Our Ref: EG/81/18/HH
Your Ref:

Town & Country Planning Act 1990 (as amended)
Town & country Planning (Development Management Procedure) (England) Order 2015
Application for Planning Permission for Works or Extension to a Dwelling

Development Proposed conservatory to the rear and side elevation.

Location 73 Barnham Road Eastergate

BLOCK/SITE PLAN
 AREA 90m x 90m
 SCALE 1:500 on A4
 CENTRE COORDINATES: 495590, 104682

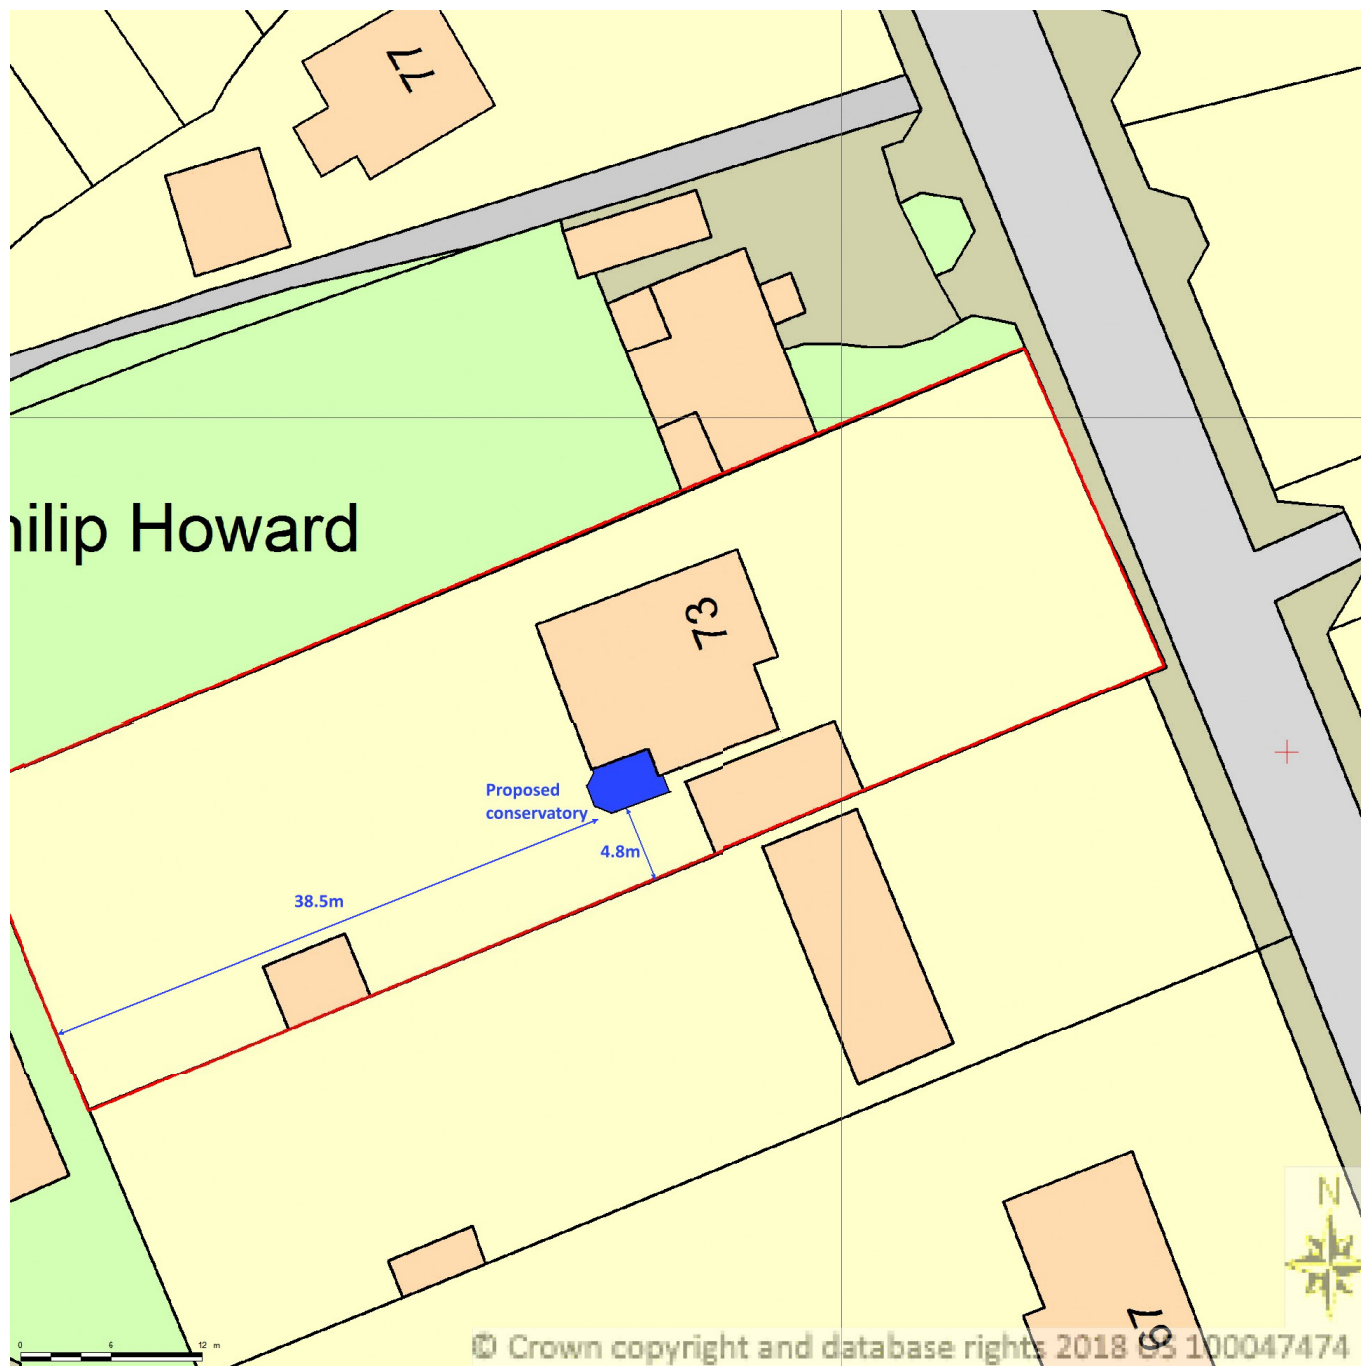
Block Plan: You are required to include a dimension from the proposed conservatory to the rear boundary on the block plan. Please amend accordingly.
